Application by EDF Energy (Thermal Generation) Limited for an Order Granting Development Consent for the West Burton C power station – Examination – Applicant’s Response to Deadline 1

Updated Landscape and Visual Impact Assessment figures: Viewpoint 13

Drawing Number	Rev
60527350/WBC/ES/FIGURE 10.5	1

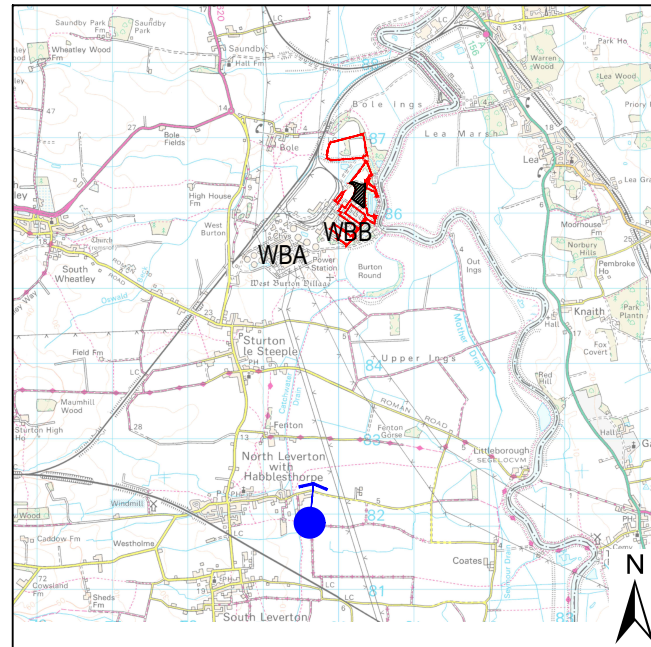
The assessment presented in APP-039 (ES Volume I, Chapter 10: Landscape and Visual Amenity) is representative of Viewpoint 13 (shown on Figure 10.18 – Revision 1). As explained above, the viewpoint location was positioned slightly further north from the originally agreed location (VP13a shown on Figure 10.18 – Revision 1). This provided a worst-case assessment, given the lack of visibility at VP13a of the Proposed Development. For completeness, an updated Figure 10.1 – Revision 1 and Figure 10.5 – Revision 1 are included in this submission.

Drawing Number 60527350/WBC/ES/FIGURE 10.18	Rev 1
---	-----------------

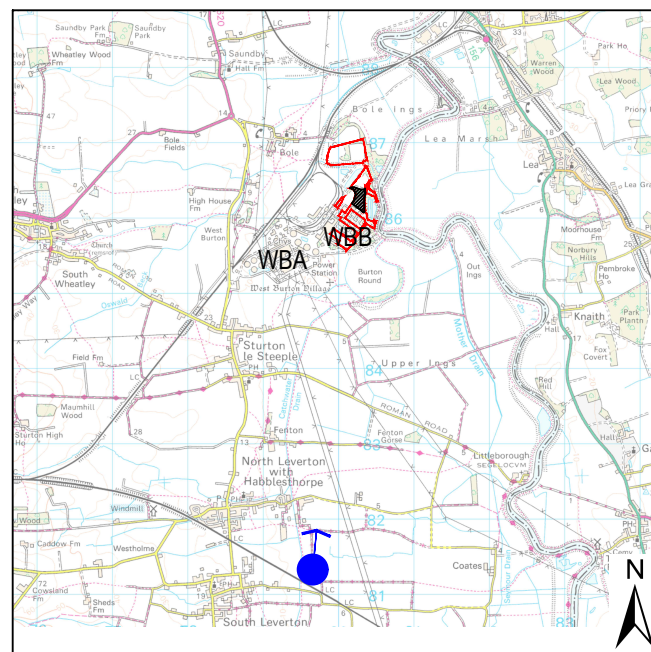
In the notes of the unaccompanied site inspection on 25th September (EV-003), the Examining Authority (ExA) raised that the location of Viewpoint 13 does not correspond with the associated photograph. The Applicant notes that the ExA is correct in that the location of Viewpoint 13 is further north along the footpath (the 'North Leverton with Hablesthorpe BOAT15'), close to the intersect of two other footpaths (the 'North Leverton with Hablesthorpe BOAT11' and the 'North Leverton with Hablesthorpe BOAT14').
